Appeal Decision

Appeal Ref: APP/R4408/W/24/3349442

52 Kensington Road, Old Town, Barnsley S75 2SS

- The appeal is made under section 78 of the Town and Country Planning Act 1990 (as amended) against a refusal to grant outline planning permission.
 - The appeal is made by Mr Jack Lycett against the decision of Barnsley Metropolitan Borough Council.
 - The application Ref is 2024/0428.
 - The development proposed is described as a “residential development”.
-

PROPOSED SITE PLAN
SCALE 1:50

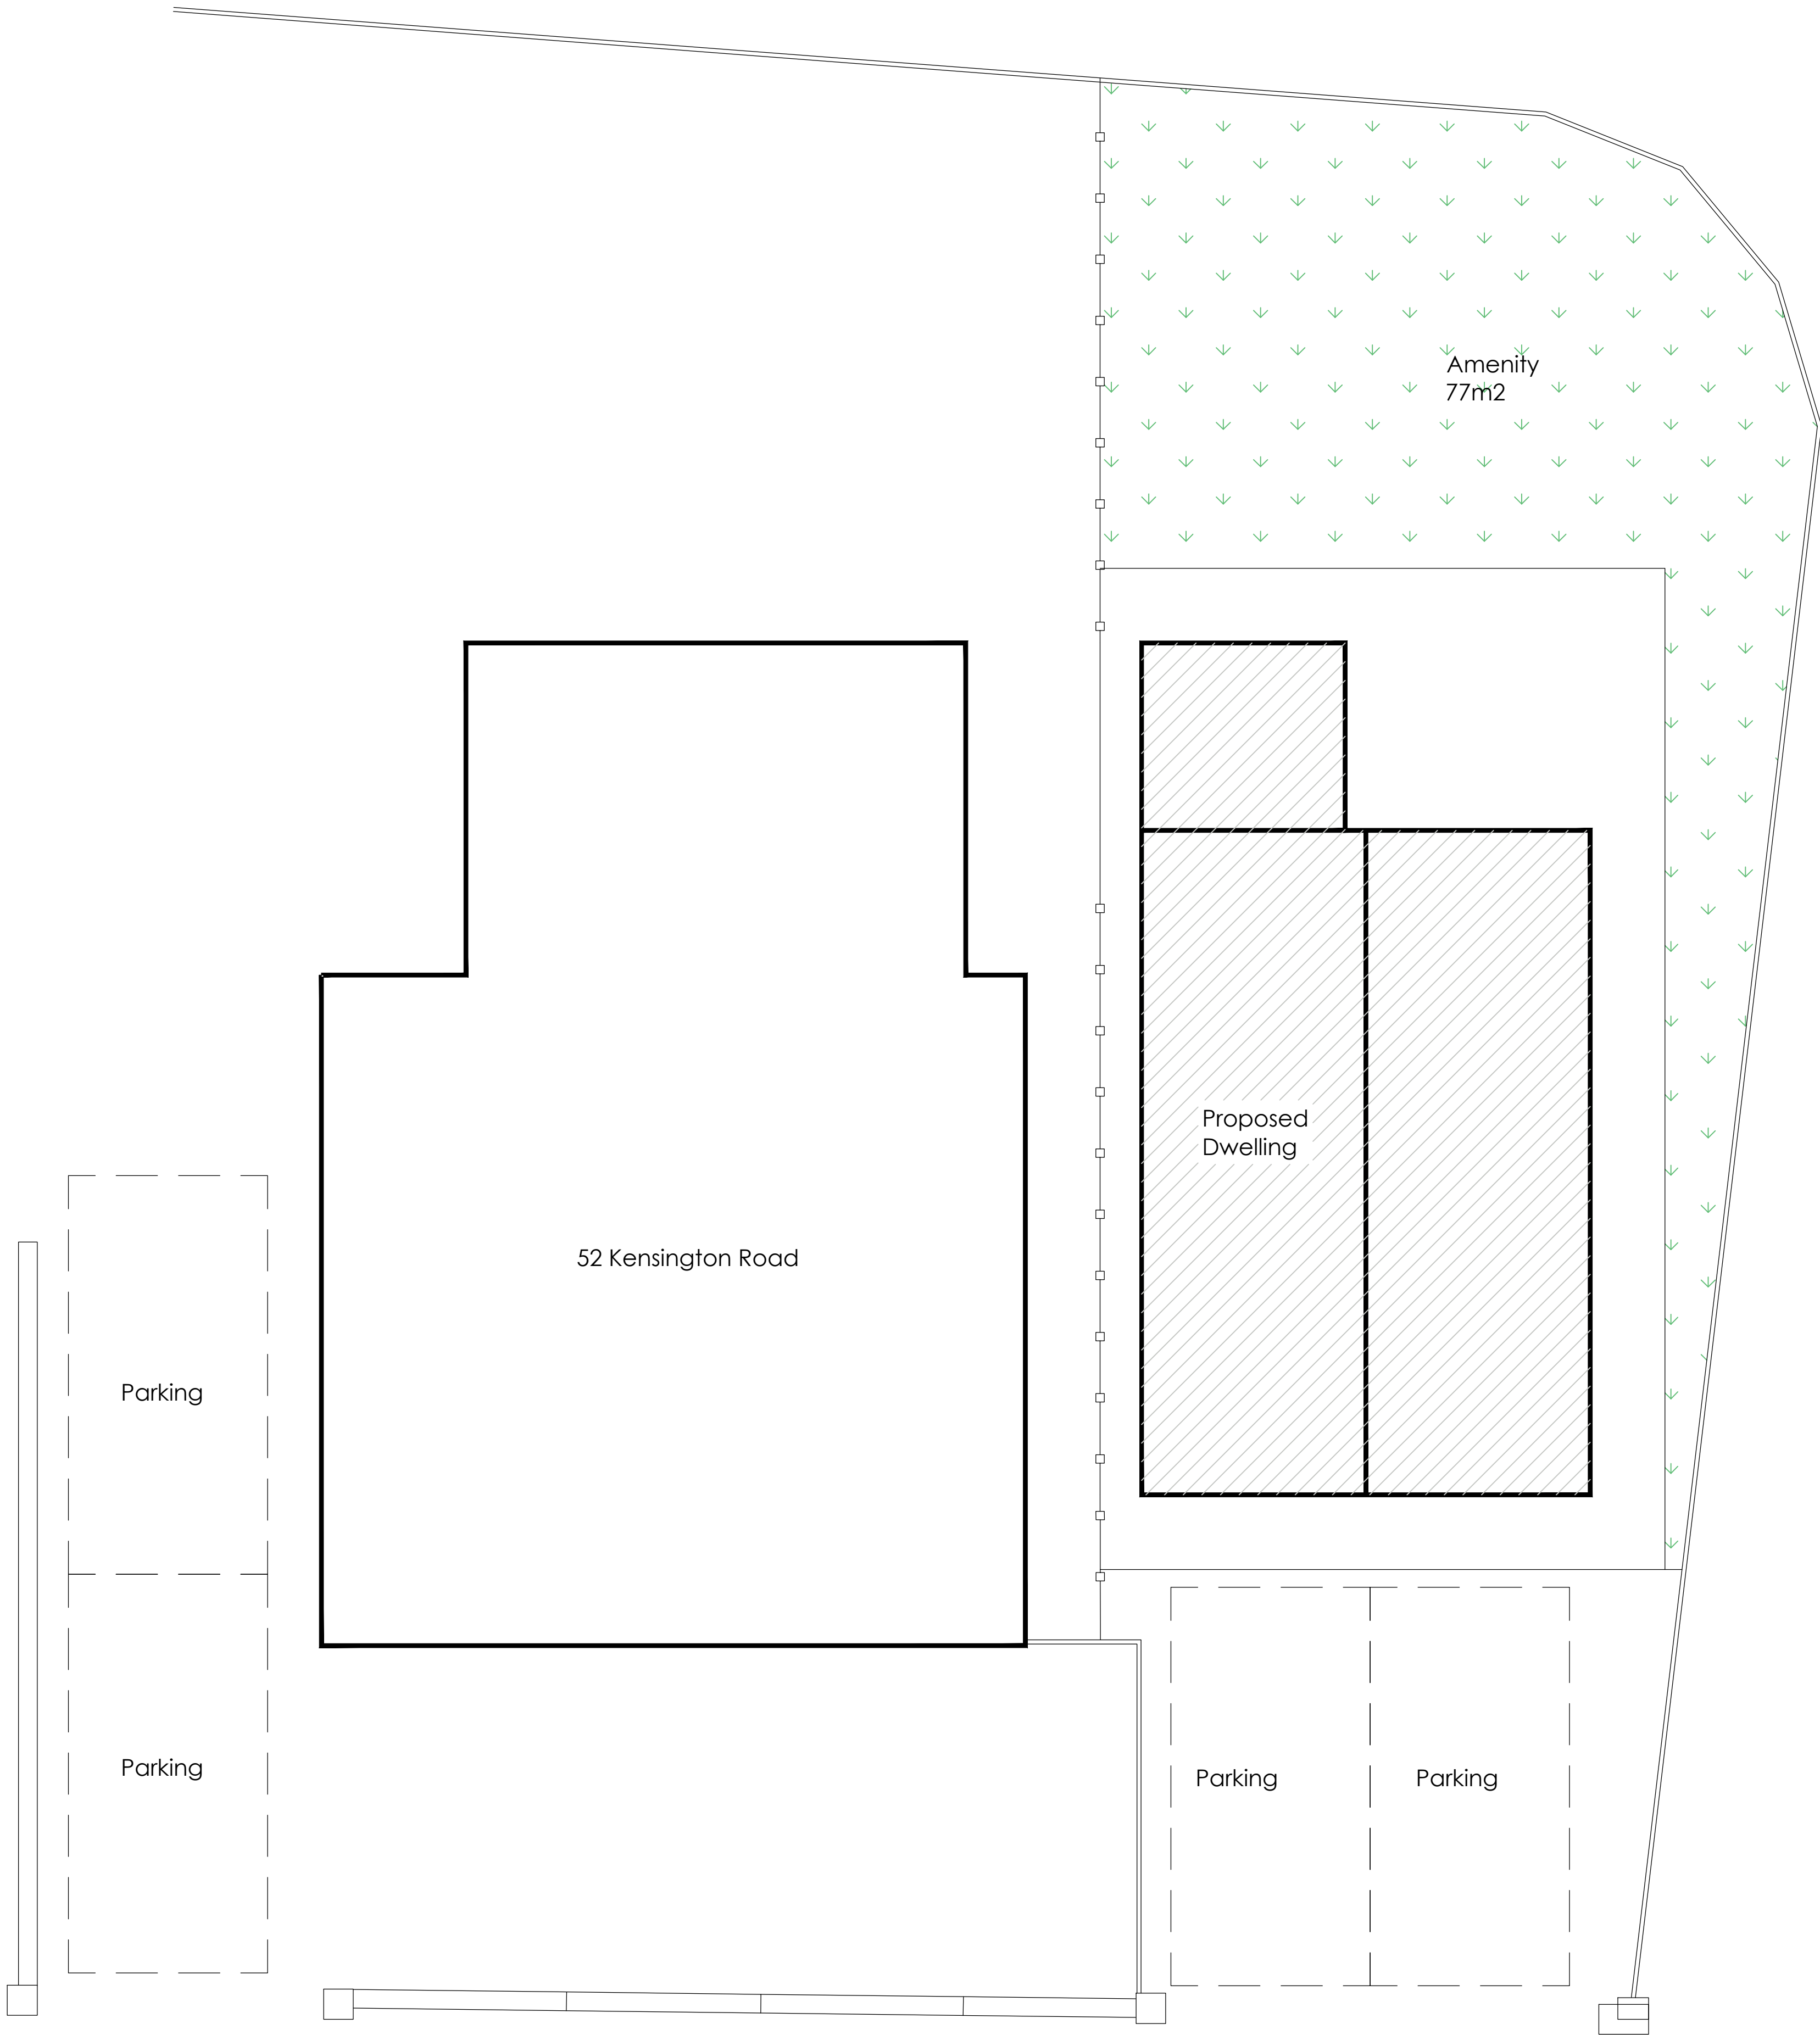
5. The appellant submitted a revised layout plan for the proposal with their appeal that repositioned the proposed parking spaces and included pedestrian visibility splays and an access from the rear garden to the pavement. The proposed amendments do not involve a substantial difference or a fundamental change to the planning application. The Council and interested parties have had an opportunity to comment upon the proposed amendments. Accordingly, accepting the revised drawing would not cause any unlawful procedural unfairness to anyone involved in the appeal. For these reasons, I have accepted the revised drawing and determined the appeal on this basis.

13. The revised drawing indicates that two off-street parking spaces would be provided to the front of the dwelling that would comply with the Council's dimensions. Pedestrian visibility splays would be achieved to either side of the parking spaces if amendments were made to the front boundary wall, and an access would be created from the pavement to the rear garden to allow for the manoeuvring of refuse bins. Consequently, the Council's Highways Development Control Officer has conceded their objection to the proposal in this regard.

14. Notwithstanding this, the Council raise concern that the proposed pedestrian visibility splay to the northeast would extend over land outside the appeal site and would require alterations to be made to the front boundary wall of 52 Kensington Road which is not included within the description of development. However, the land is within the appellant's control and therefore, the visibility splay and the associated works could be conditioned. Furthermore, the works do not need to be explicitly included within the description of development.

18. Both the appeal site and the proposed dwelling would be significantly narrower than other plots and dwellings in the surrounding area. Furthermore, the space between the proposed dwelling and No 52 would be much smaller than existing gaps between the buildings along the southern side of the road. Consequently, the proposed dwelling would appear cramped within a constrained site that would appear alien to the existing spacious character.

of the road. Two off-street parking spaces would be provided in front of the dwelling which would necessitate the removal of the front boundary wall. This would be incongruous with the enclosed front gardens in the surrounding area.
